Technical Note

Project No: ITB14224
Project Title: Nursery Fields
Title: ITB14224-015
Ref: LHA and PROW Response
Date: 25 February 2021

- 1.1 Landform Bersted Ltd (Landform) has submitted a planning application to Arun District Council (ADC) for 225 new homes on land to the north of Chalcraft Lane known as Nursery Fields (planning ref: BE/148/20).

APPENDIX D. PROW CONNECTIVITY PLAN

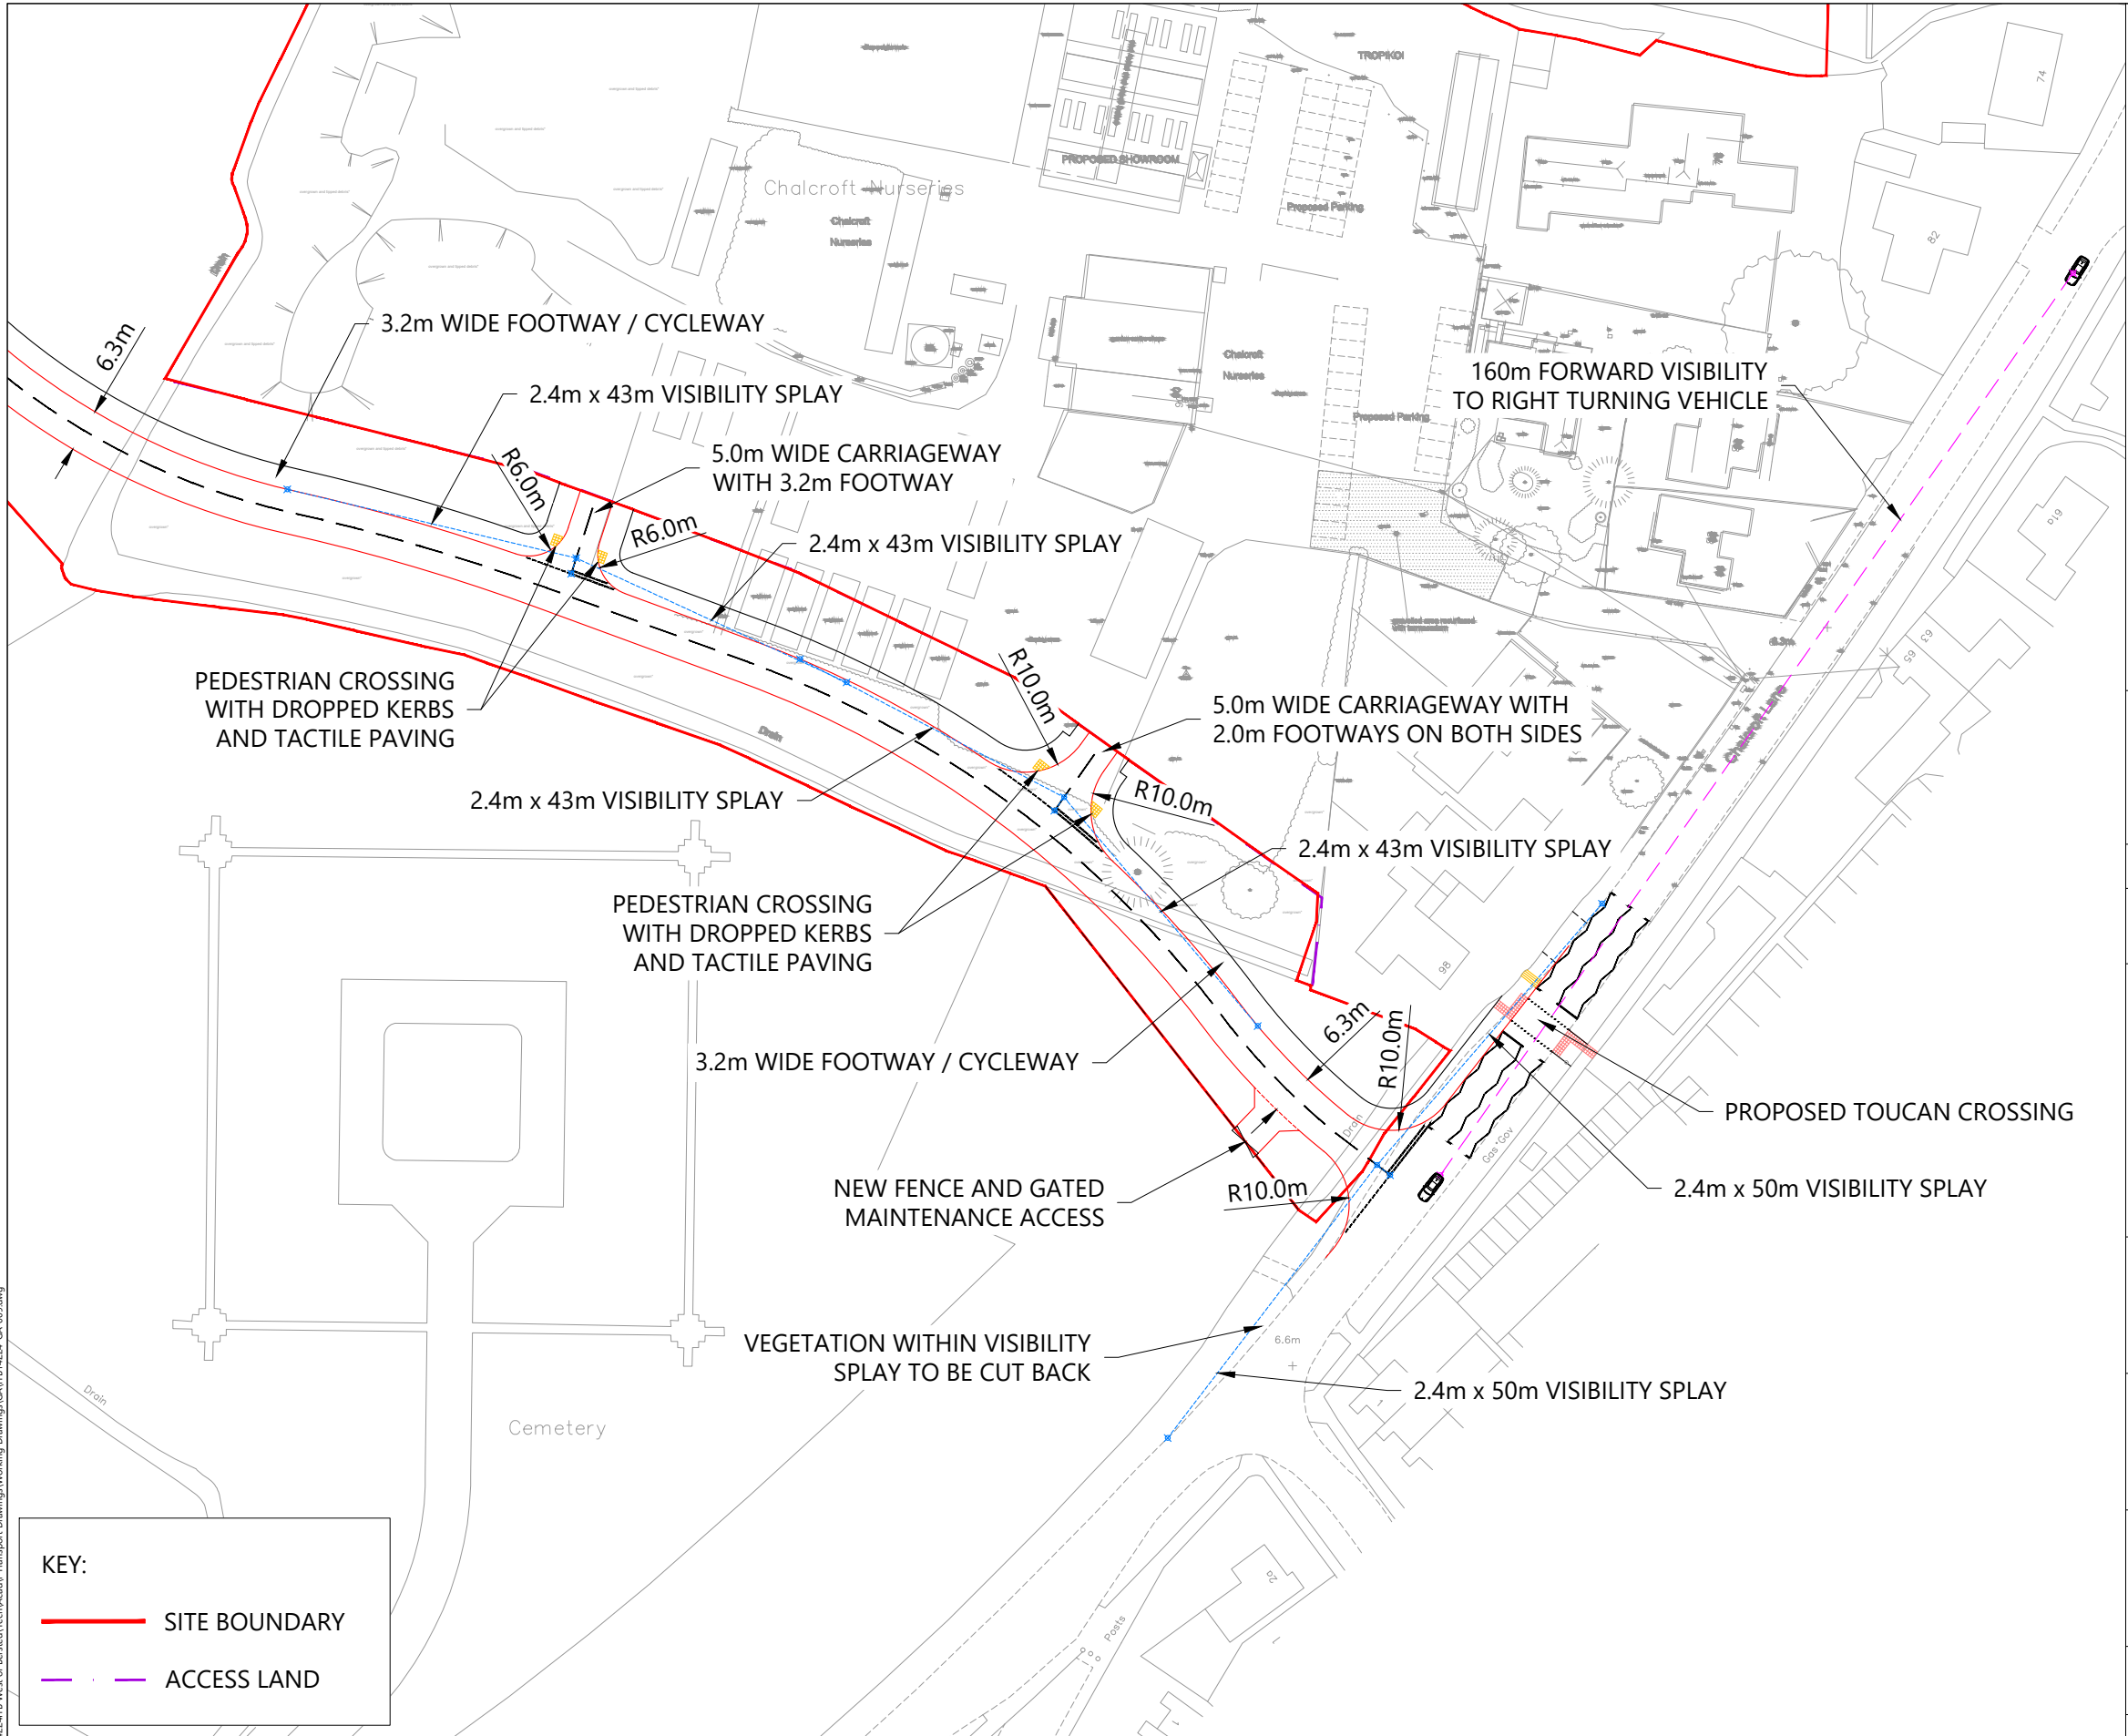
3.3 Cycle Connection Between FP136 and Existing Cycle Route

26. Through the design of the on-site layout, the use of the other two pedestrian/cyclist access points should be further promoted. This would necessitate changes to the Green Infrastructure Parameter Plan. The Parameter Plan currently shows a very indirect connection through the site onto the existing cycle route on the community centre access road. A far more direct and convenient route could be achieved.

- 3.1.1 Comment from the WSCC PROW Team express support for the upgrade of Footpath 134, and WSCC Highways has indicated that improvements to provide a connection to the B2259 using FP134 should be secured via condition.
- 3.1.2 It should be noted that WSCC are already in receipt of a financial contribution of £50,000 to undertake and enhance the route through to the B2259, secured through the planning consent associated with Landform application BE/142/15, to provide widening and resurfacing to make it suitable for use as Bridleway. As such, it would not be necessary to secure any further works. The Nursery Fields development will provide a direct connection to the improved section of FP134, as denoted on the PROW Connectivity Plan at **Appendix D**.

- 3.2.1 The route through the site along FP136 is to be upgraded for use by cyclists and the WSCC PROW Team express support for this enhancement. As sought by the PROW Team, the cycle provision is not to be extended to provide a cycle connection through to Chalcraft Lane on its current alignment, with the route turning northwards to provide a connection to the existing cycle link along the access road to the community hall. The PROW Connectivity Figure has been updated to reflect this arrangement (Appendix D).
- 3.2.2 The existing FP136 route is identified on the Parameter Plan and Green Infrastructure Plan (Appendix C). The existing route of the FP will be kept on its current alignment and, where necessary, the cycle route will taken off this alignment to avoid retained hedgerows and root protection areas of retained trees.

- 3.3.3 Signage will be introduced to direct cyclists north, and the remainder of FP 136 to the site boundary will be improved for use by pedestrians only. A financial contribution will be made to enable WSCC PROW to resurface the remaining section of FP136 outside of the site boundary.

SITE ACCESS PLAN (REF: ITB14244-GA-009)

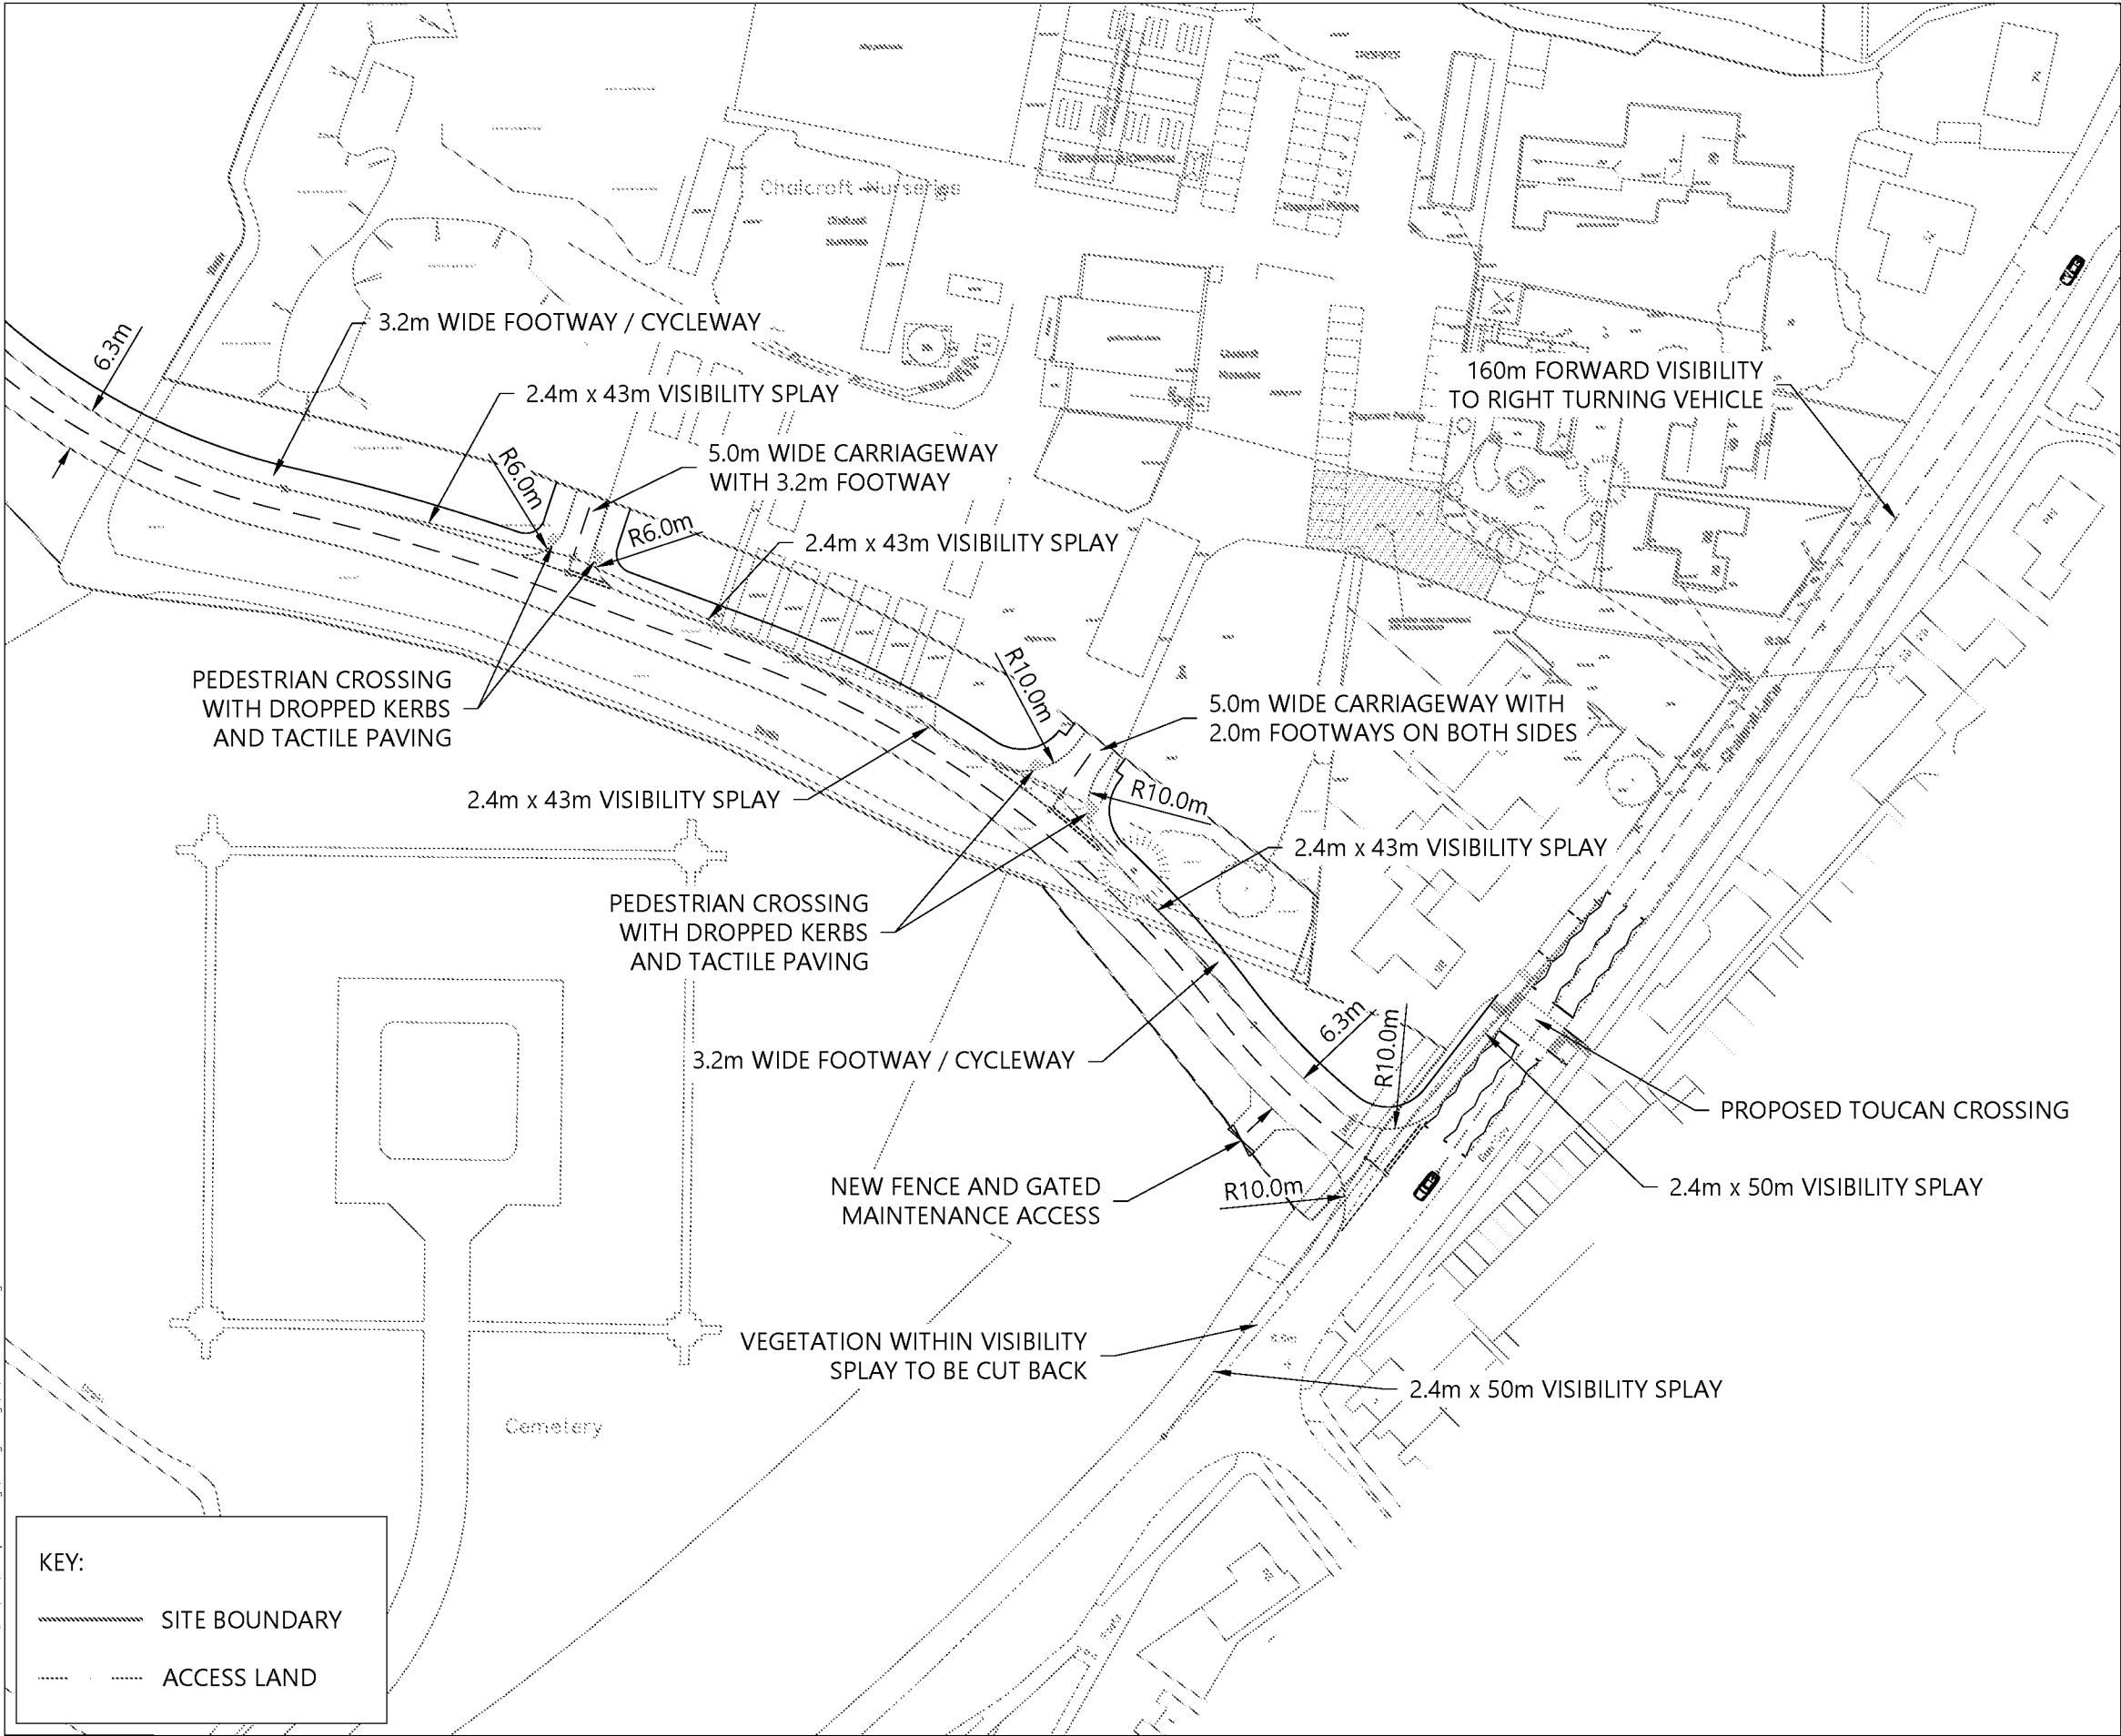
- 2.2 WSCC has advised that they are satisfied with the proposed site access arrangement, subject to confirmation that the Stage 1 Road Safety Audit has considered the arrangement on the basis of it serving all traffic from the Chalcraft Nursery and Nursery Fields developments.

- 2.4.1 WSCC has requested that the cycle infrastructure adjacent to the site access road and the associated infrastructure along Chalcraft Lane (including a Toucan crossing) is removed, focussing cycle access

towards the community centre access road and existing cycle infrastructure along this corridor towards Bognor Regis.

7. It's understood that the priority junction would have been the subject of a Stage One Road Safety Audit for BE/81/20. The provision of a Stage One RSA is a WSCC policy requirement for all major applications. However it's unclear if the Road Safety Auditor has reviewed the proposed access arrangement on the basis that this would serve both the current application and the development proposed within BE/81/20. Whilst a further new Road Safety Audit is not necessarily required, confirmation is still sought from the applicant that the Safety Auditor has considered the vehicular access on the basis of all development that will now use it.

8. Related to the above point, although the vehicular access remains effectively unchanged, the access drawing now includes a Toucan controlled crossing to the immediate north. Further comments are made on the Toucan crossing and related infrastructure within the 'Access by Sustainable Modes' section.

23. In respects of the current application, a shared foot/cycle way is indicated on the north side of the access road serving the development (it's acknowledged that details of the access road are not to be approved at this stage although such matters are shown on the Green Infrastructure Parameter Plan that is to be approved) linking into a Toucan crossing on Chalcraft Lane. The existing footway on the eastern side of Chalcraft Lane is indicated to be widened to 3.2 metres from the Toucan crossing to Central Drive, from where cyclists will join the carriageway. There is very limited consideration within the TA in terms of how this proposed arrangement complies with current guidance. LTN 1/20 in particular advises against shared use foot/cycle ways and instead promotes the physical segregation of cyclists and pedestrians.

24. Given that the site is indicating pedestrian/cyclist accesses at two other points (namely via footpath 136 (notwithstanding the potential issues identified with this) and onto the community centre access road (which connects to an existing Toucan crossing linking to Central Drive), the provision for cyclists alongside the main access road and the associated works on Chalcraft Lane are potentially superfluous and as shown conflict with LTN 1/20.

25. It's recommended that this aspect (namely the provision of shared use facility within the development, the Toucan crossing, and the proposed widening works along Chalcraft Lane) of the application is either removed or reassessed and amended to ensure compliance with LTN 1/20. In the event this southern route is removed, the Green Infrastructure Parameter Plan would need to be updated.

- 2.3 The Audit was instructed on basis that it would serve both parcels of development. Confirmation has been obtained from the Auditor in this respect and a copy of the correspondence is provided at **Appendix B**.

- 2.4.2 The site access drawing has been amended to reflect these amendments and the revised arrangements are presented as **Drawing ITB14224-GA-009 Rev B**. Similarly, the Land Use Parameter Plan and the Green Infrastructure Plan have also been updated and copies of these are provided at **Appendix C**.

- 4.4 The pedestrian and cycle access arrangement has been amended in accordance with the request of WSCC. The Toucan crossing and associated cycle infrastructure has been removed, to focus movements toward the existing cycling corridor. Confirmation has been provided by the Road Safety Auditor that the site access arrangements have been audited on the basis of access being provided to both the Chalcraft Nursery and Nursery Fields developments.
